10. **Project# 1005247**  
 11DRB-70297 VACATION OF PRIVATE EASEMENT  
 11DRB-70298 MINOR - PRELIMINARY/FINAL PLAT APPROVAL
- THE SURVEY OFFICE LLC agent(s) for BEN D COHEN TRUSTEE COHEN LIVING TRUST request(s) the above action(s) for all or a portion of Lot(s) 30-A & 30-B, Block(s) 10, **NORTH ALBUQUERQUE ACRES Unit(s) B**, zoned SU-2 M-1, located on OAKLAND BETWEEN SAN MATEO AND I-25 containing approximately .9995 acre(s). (C-18) **THE VACATION WAS APPROVED AS SHOWN ON EXHIBIT B IN THE PLANNING FILE PER SECTION 14-14-7-2(A) (1) AND (B) (1)(3) OF THE SUBDIVISION ORDINANCE. THE PRELIMINARY/FINAL PLAT WAS APPROVED WITH FINAL SIGN OFF DELEGATED TO TRANSPORTATION TO PROVIDE DIMENSIONAL EXHIBIT AND TO PLANNING TO ADD DRAINAGE EASEMENT.**

# DRB CASE ACTION LOG (PREL & FINAL)

Project # **1005247**

Project Name **NO ALBUQ ACRES, UNIT B**

PLAT OF
LOTS 30-A-1 & 30-B-1, BLOCK 10
TRACT A, UNIT B
NORTH ALBUQUERQUE ACRES
PROJECTED SECTION 13, T. 11 N., R. 3 E., N.M.P.M.
ELENA GALLEGOS GRANT
CITY OF ALBUQUERQUE
BERNALILLO COUNTY, NEW MEXICO
OCTOBER 2011

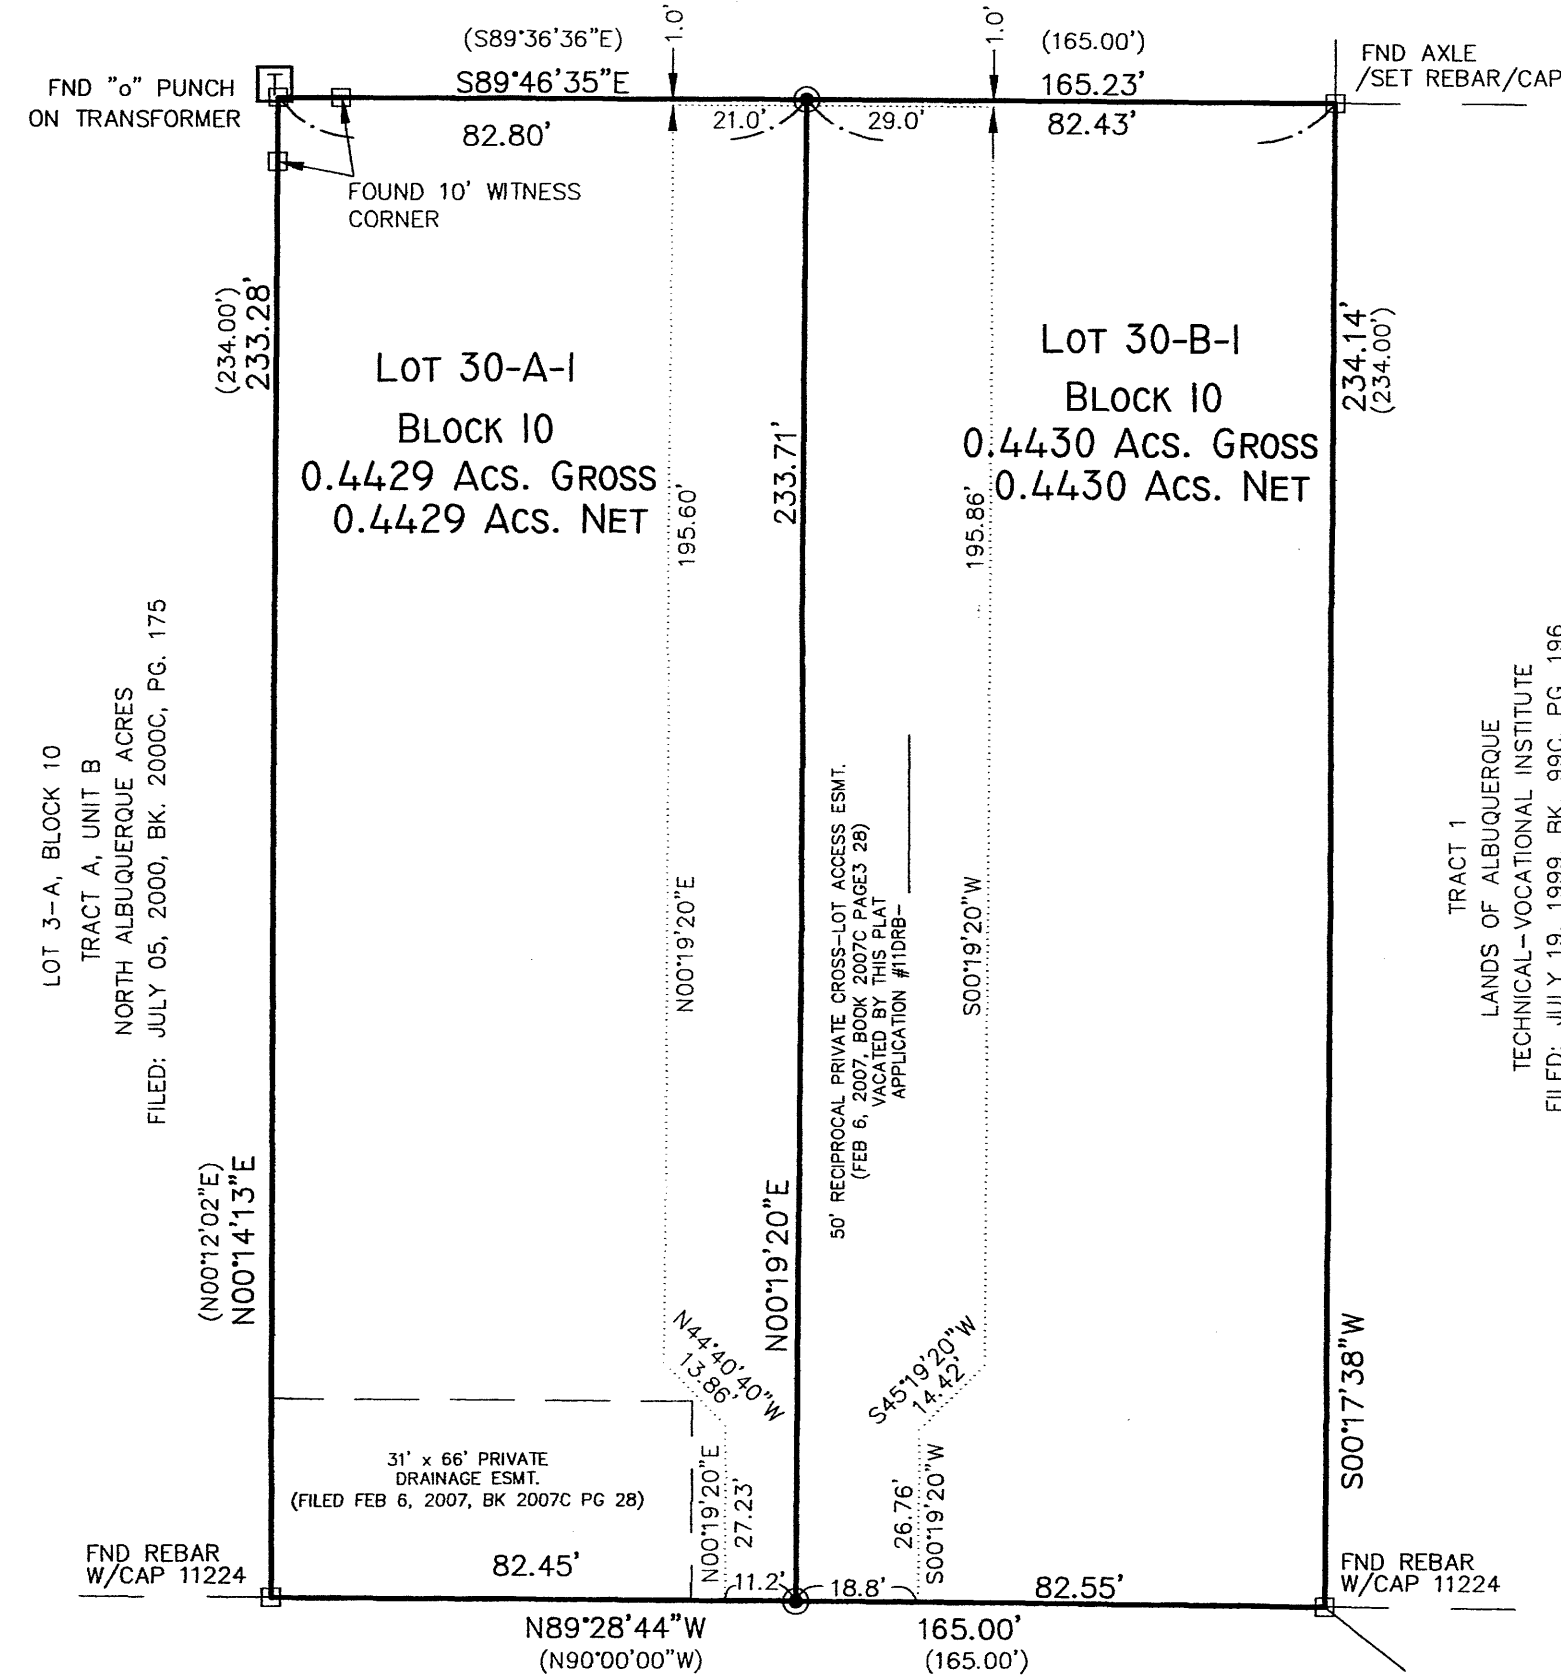
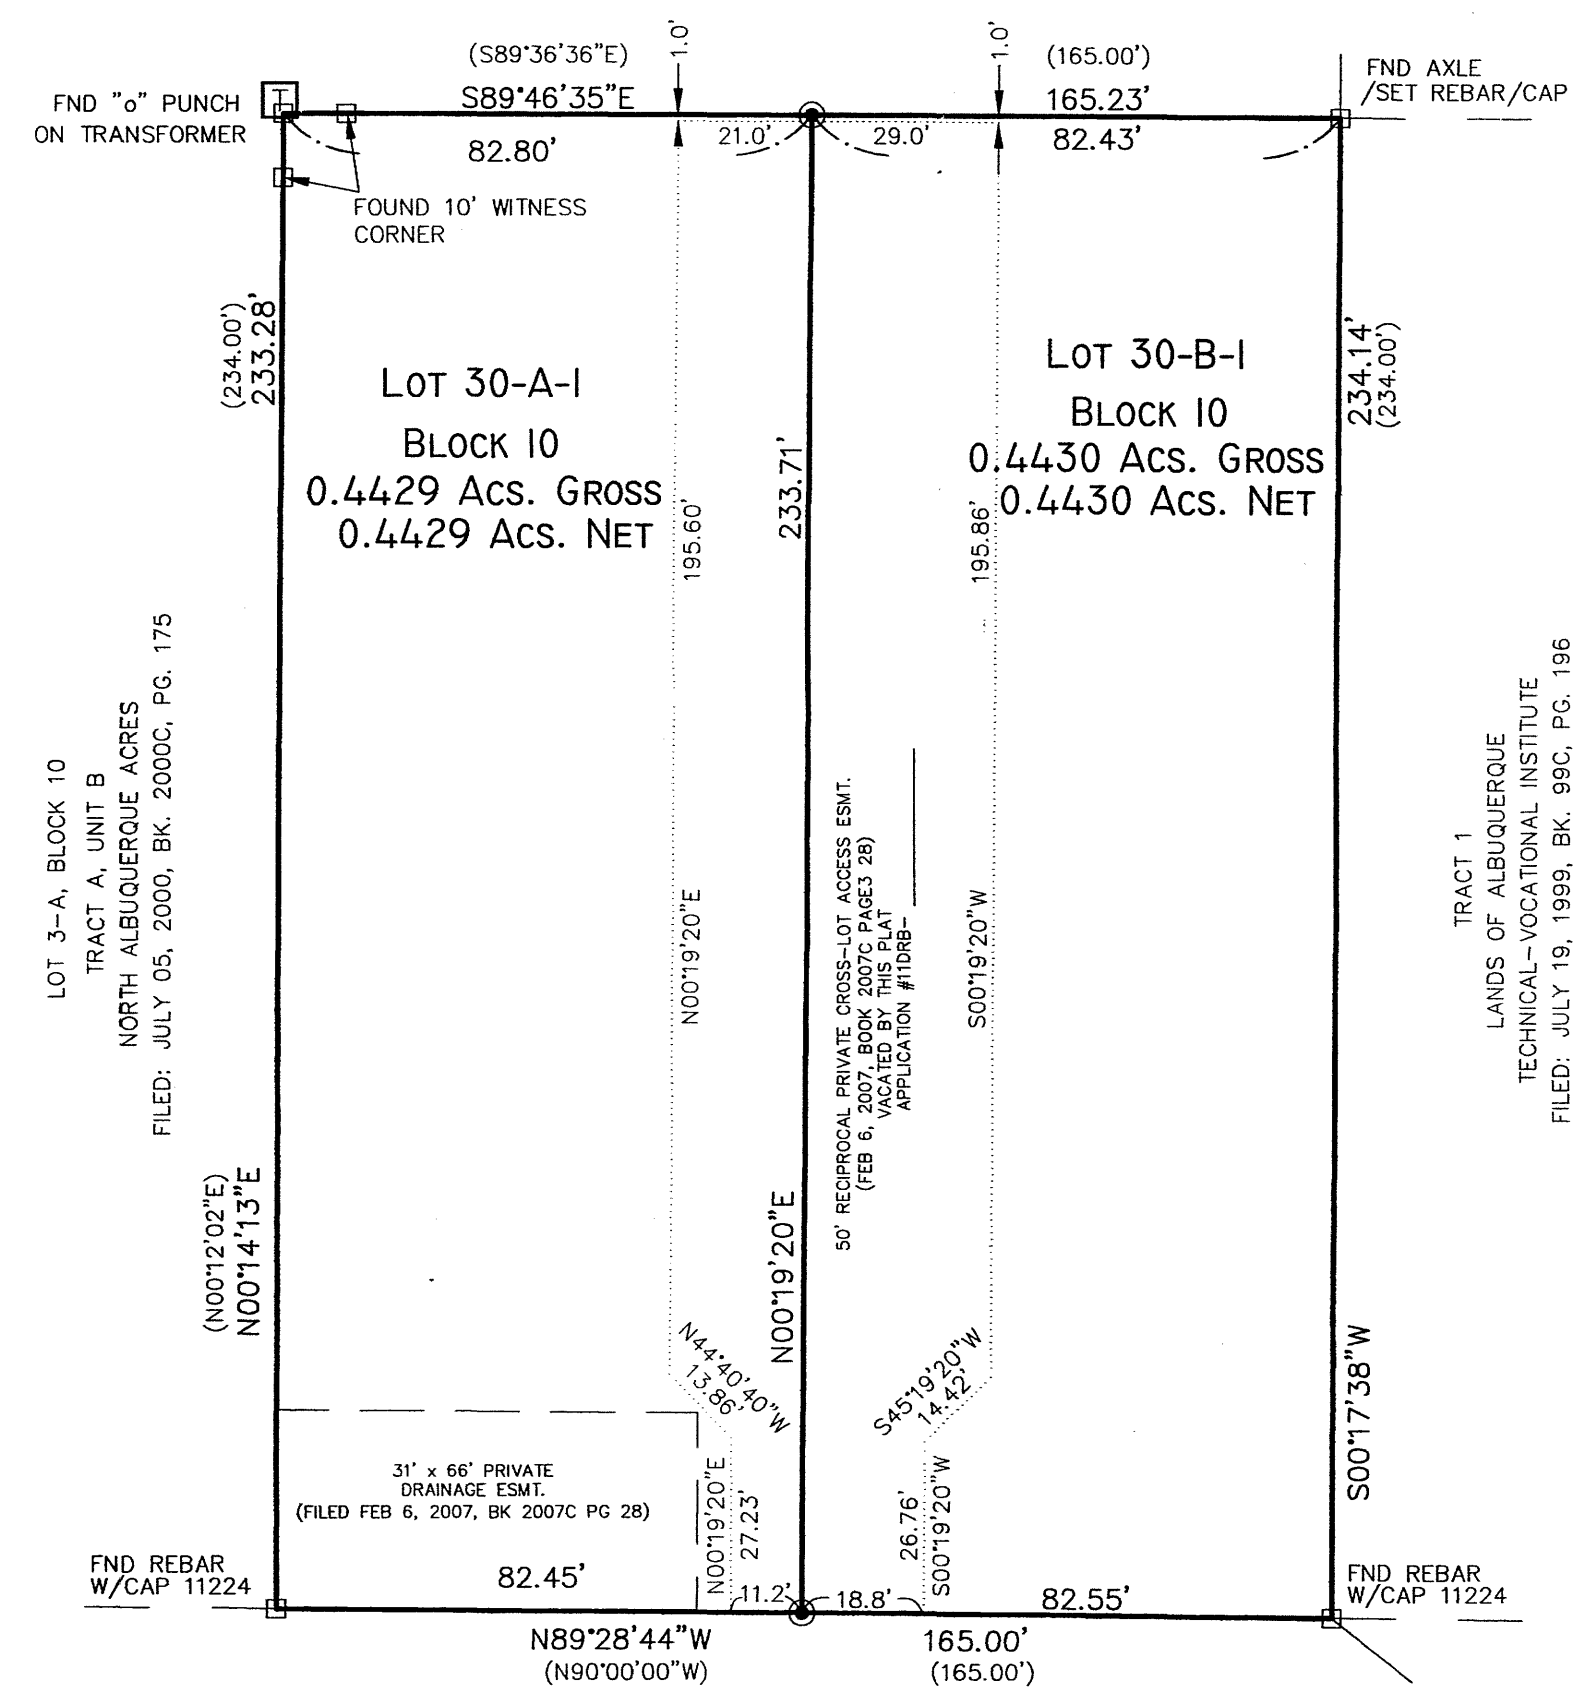
A cross lot drainage easement is needed.
